**Re: Eckerd Drug Store, 110 Juan Tabo Blvd. NE, Traffic Circulation Layout  
Engineer's Stamp dated 11-27-03 (L22/D11B)**

**Re: Eckerd Drug Store, 110 Juan Tabo Blvd. NE, Grading and Drainage Plan  
Engineer's Stamp dated 11-26-03 (L22/D11B)**

**Re: Eckerd Drug Store, 110 Juan Tabo Blvd. NE, Traffic Circulation Layout  
Engineer's Stamp dated 9-05-03 (L22/D11B)**

**Re: Eckerd Drug Store, 110 Juan Tabo Blvd. NE, Grading and Drainage Plan  
Engineer's Stamp dated 9-04-03 (L22/D11B)**

C-3

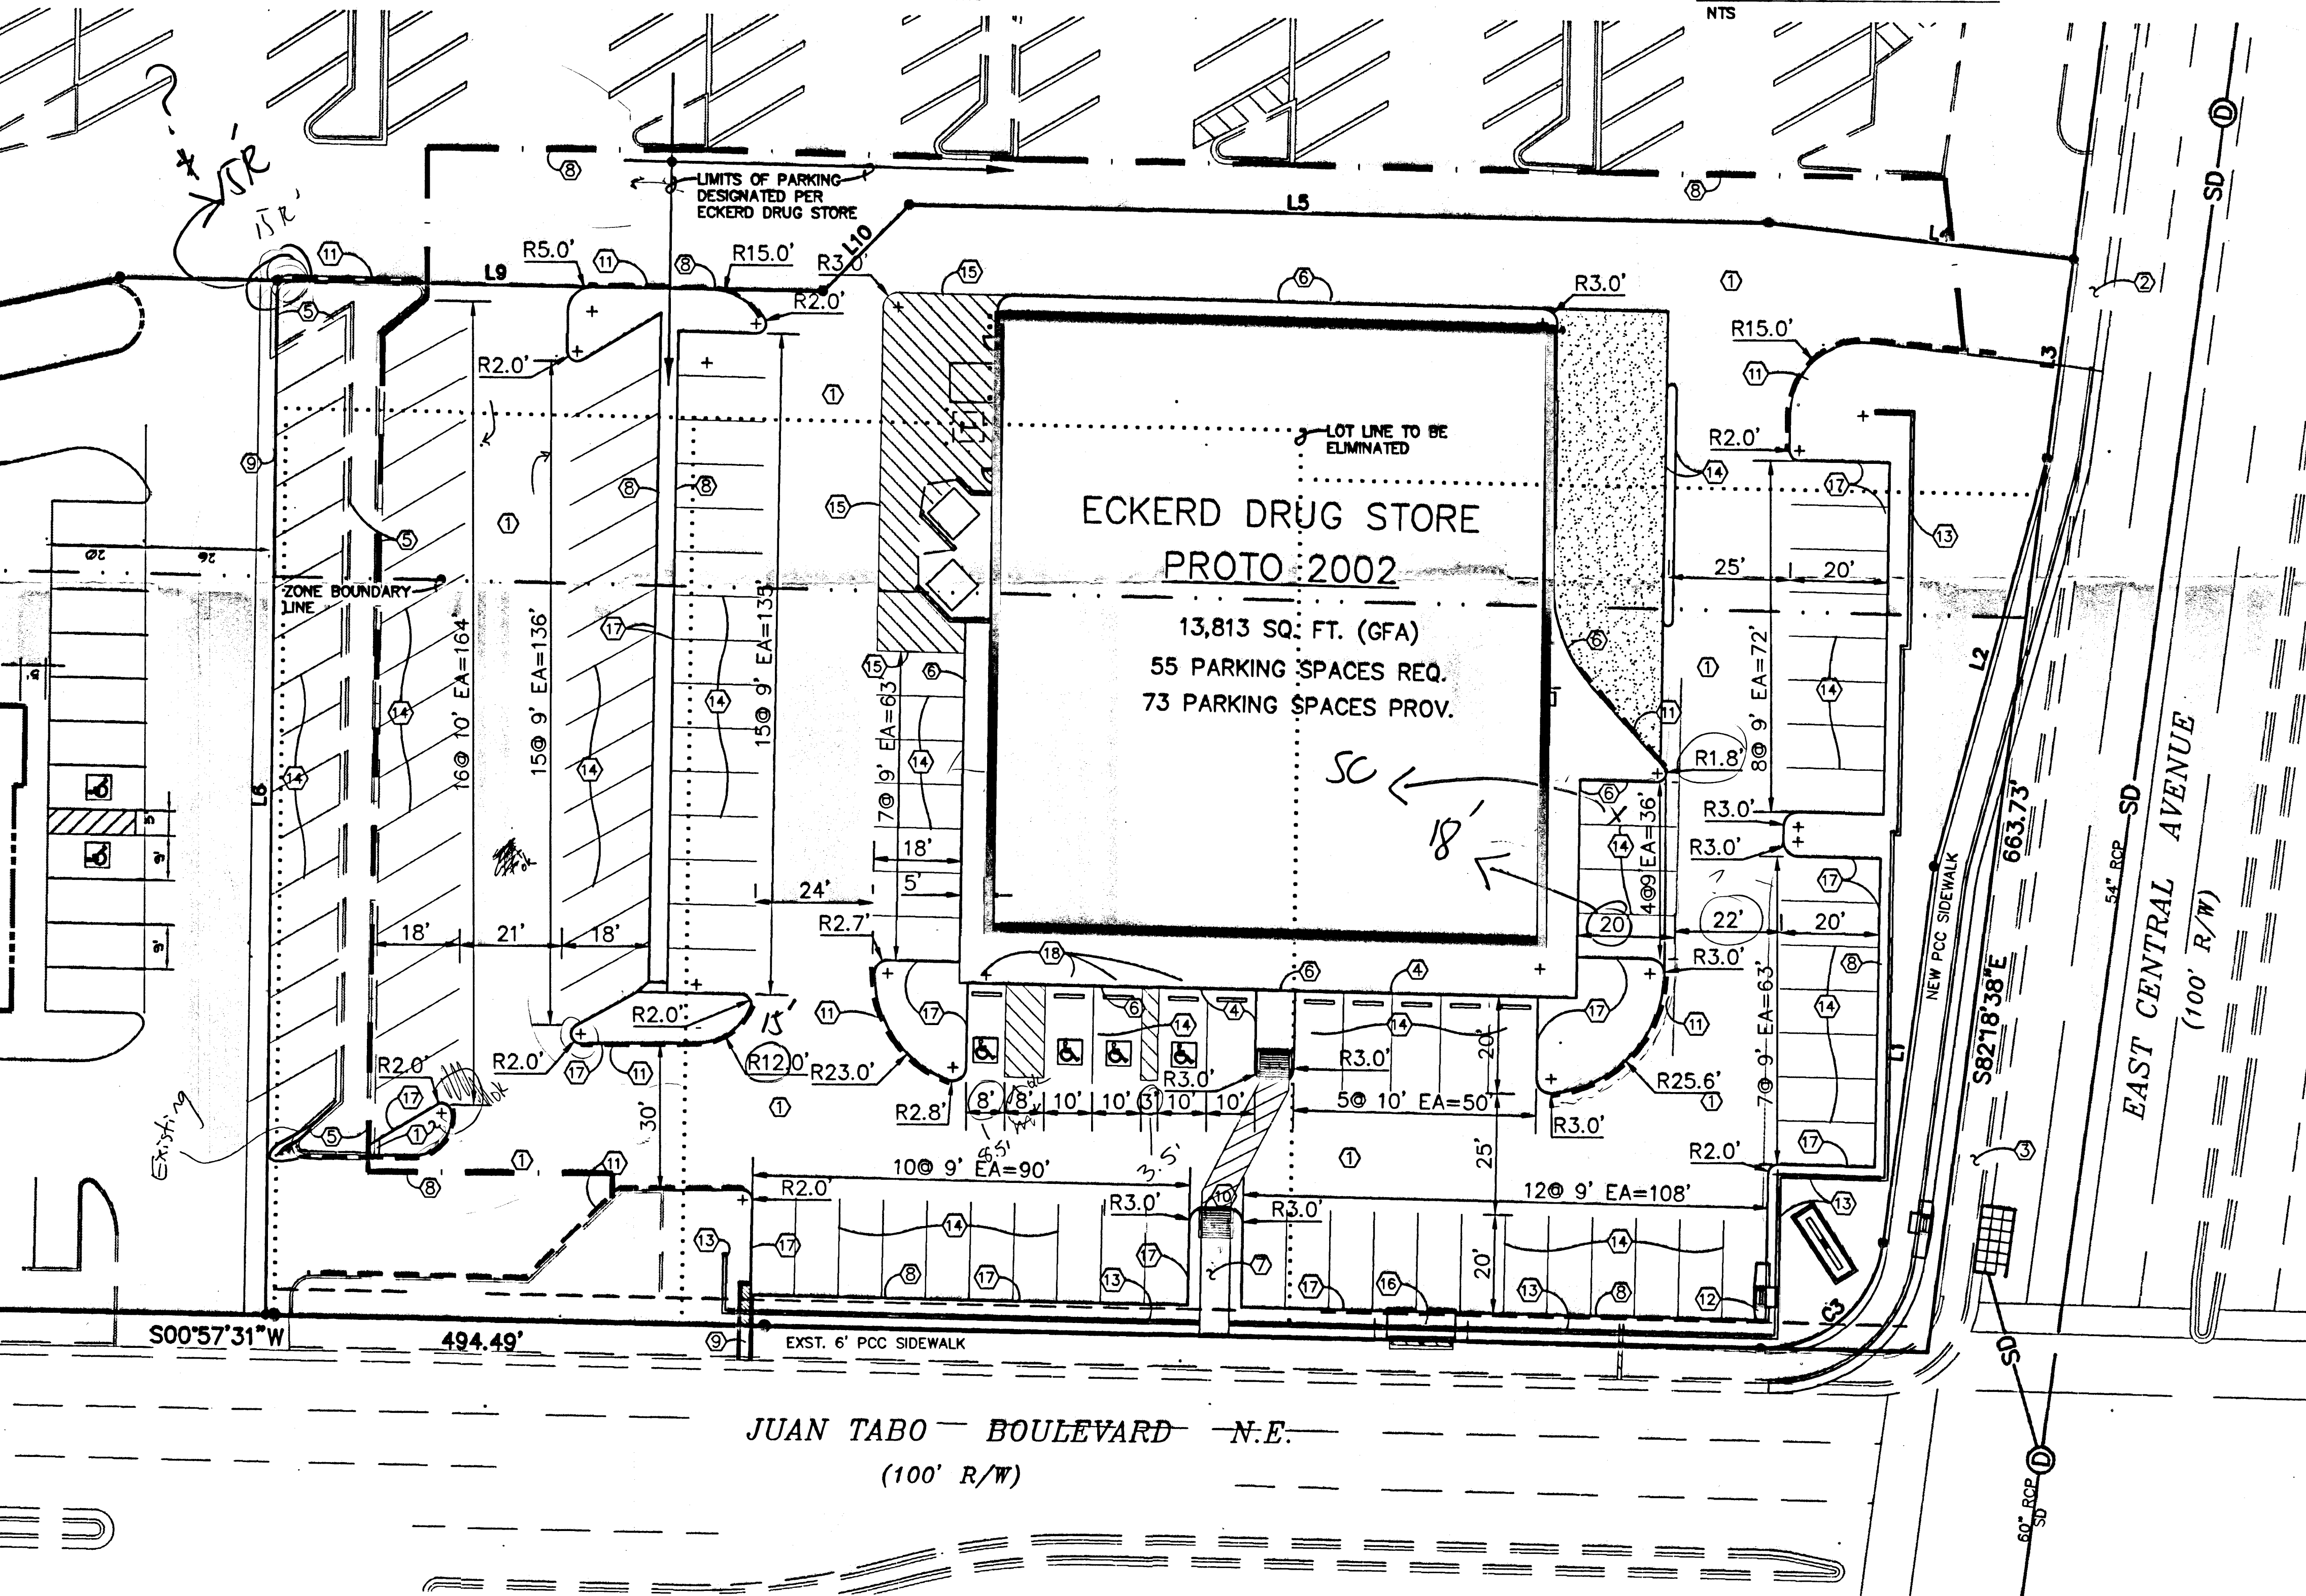
Prior to Certificate of Occupancy release, the handicapped spaces must be a minimum of 8.5 feet in width, with one van accessible aisle (8 foot width) and one normal aisle (3.5 foot width). Engineer Certification of this plan will be required.

1. Please list the horizontal width of all parking spaces.
2. The parking spaces at the northern property line have a scaled length of approximately 15 feet. However, the required width is 18 feet. Please update your plans accordingly.
3. Please include a copy of your shared access agreement with the adjacent property owner.

C-1

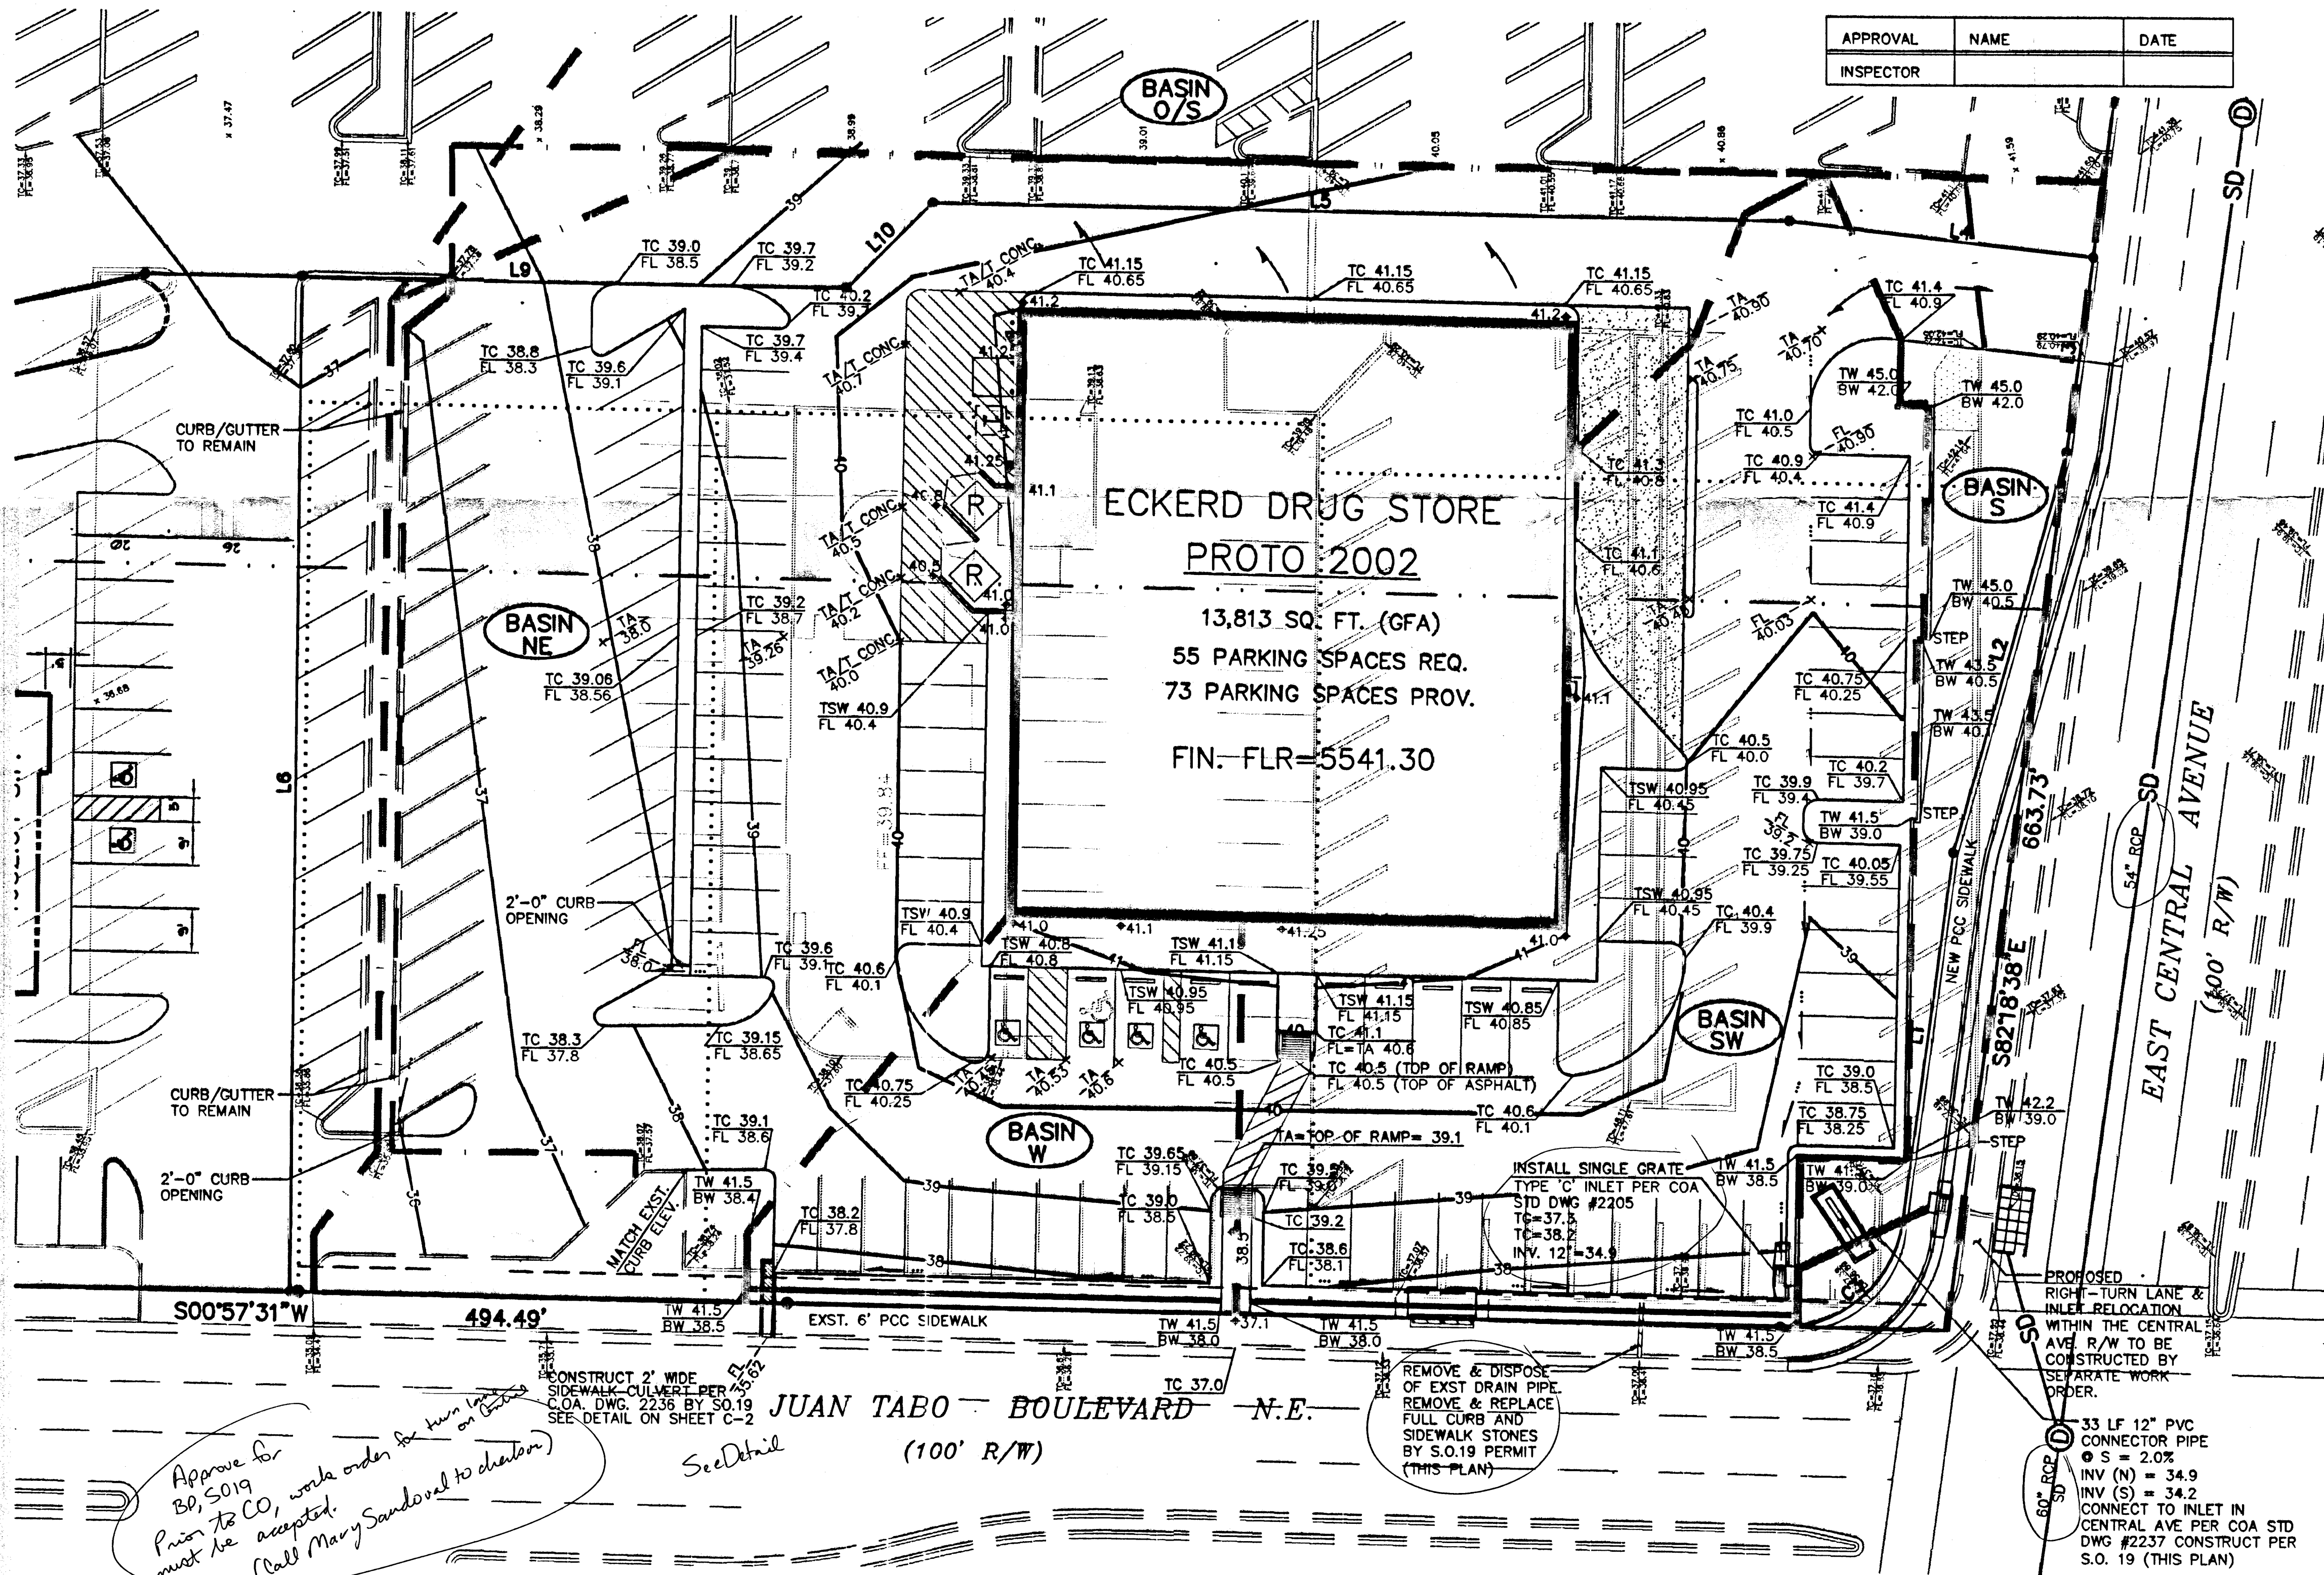
A separate permit (SO#19) is required for construction within City Right of Way. A copy of this approval letter must be on hand when applying for the excavation permit. Prior to Certificate of Occupancy release, the work order for the right turn lane on Central must be accepted. Engineer Certification per the DPM checklist will be required.  
*by the City (Call Mary Sandoval to check on this)*

1. Please define the proposed site's proximity to the flood plain.
2. Since an S.O. 19 permit is necessary, please include two copies of the corrected plan.

3. Refer to the City of Albuquerque Standard Specifications Update 7 (January 2003) in the notice to contractors.
4. Show more detail for the proposed sidewalk culvert.

5. Please remove the existing drain pipe.
6. List the proposed work order number for the work along Central Ave.
7. Define the type of inlet proposed and show the connection.

8. Reference city standard drawing number 2237 at the inlet/connector pipe connection.
9. Define the size of the existing storm drain along Central Ave.

10. Your notes define a type SC catch basin. The City of Albuquerque does not define a type SC catch basin; please give further detail.
11. Please show the drainage basins on the drawing.

12. Are you creating a new lot for the Eckerd Drug Store?
13. Please address downstream capacity.

*If ~~new~~ new lot,  
will need permission  
to drain / work  
on other lot*
